S/AR/2010/229

Proposal: Redevelopment of site: Demolition of 2 bungalows, workshop, glasshouses and incidental development with erection of 91 dwellings with improved means of access onto worthing road with all other matters reserved. Site: Windroos Nursery, Worthing Road, Littlehampton, West Sussex BN17 6LY. LU/229/10/

Network Development
Atkins Ltd, for Southern Water

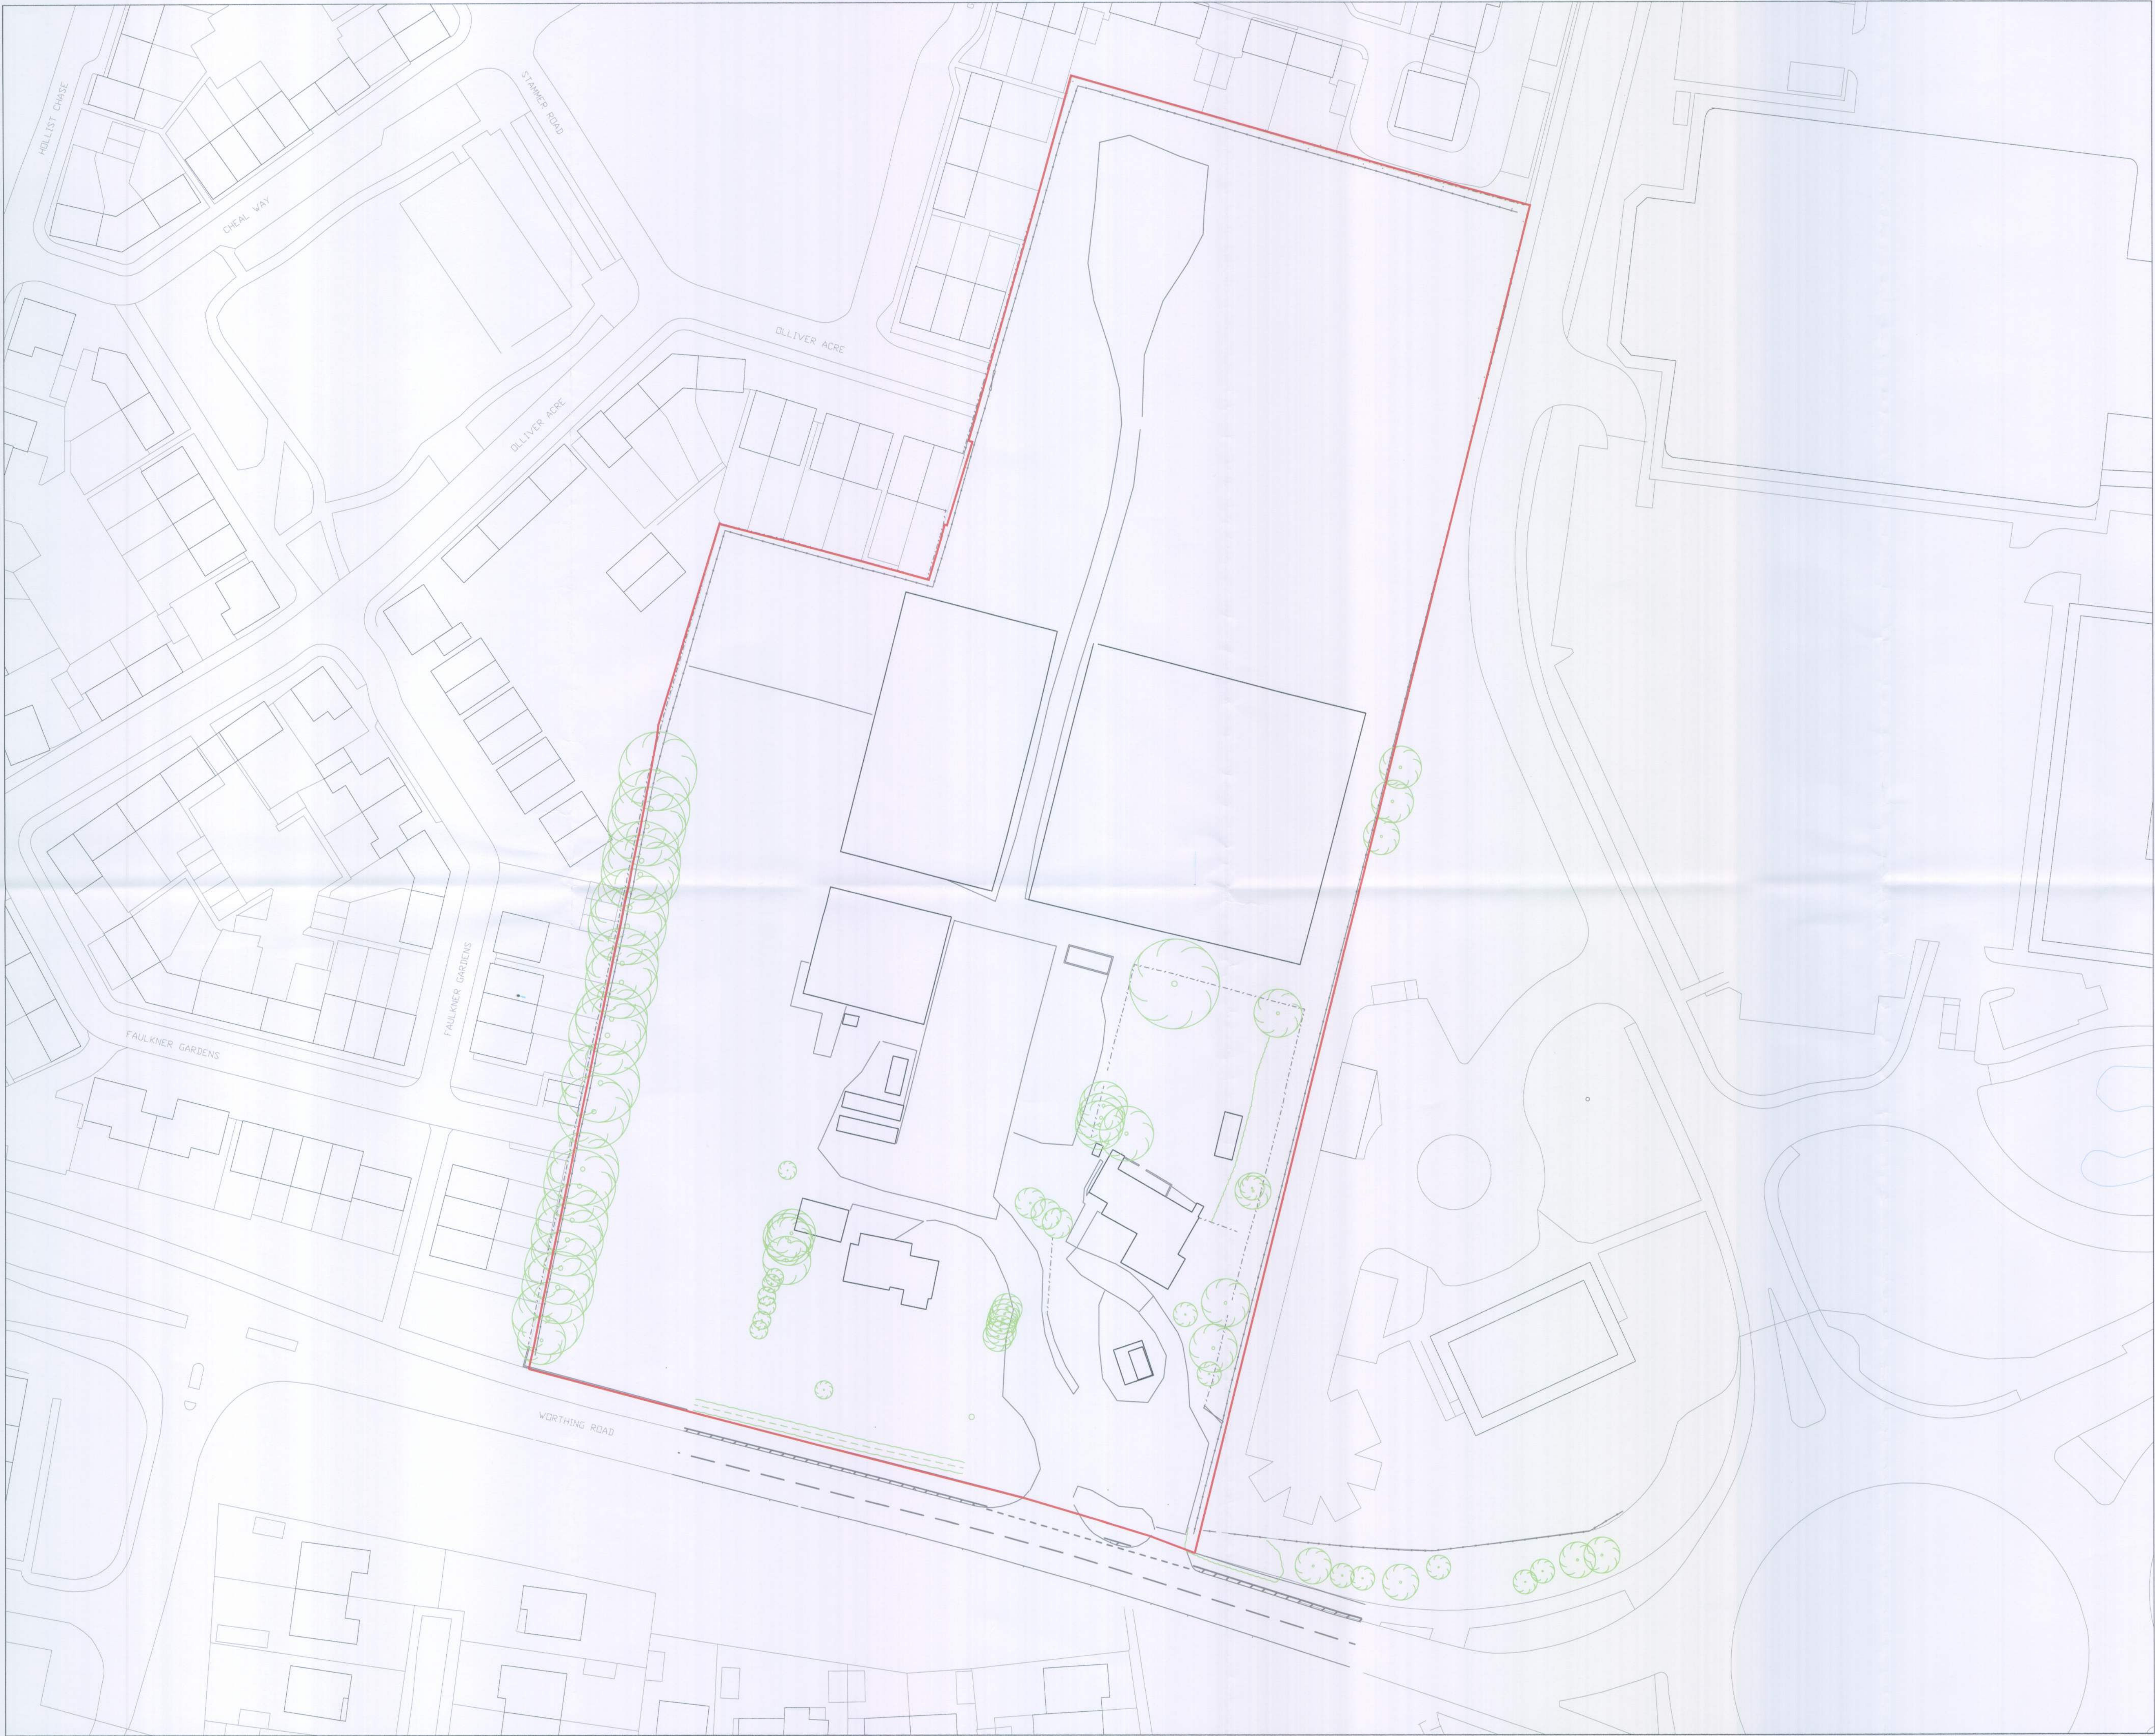
SUDS systems usually have a significant land take and it is not clear how the SUDS facilities can be accommodated within the proposed layout. Before the proposed layout is approved, we advise that the applicant/developer give consideration to ensure that the proposed means of surface water disposal can be accommodated within the proposed layout.

We request that should this application receive planning approval, the following condition is attached to the consent: "Construction of the development shall not commence until details of the proposed means of surface water disposal have been submitted to, and approved by, the Local Planning Authority in consultation with Southern Water".
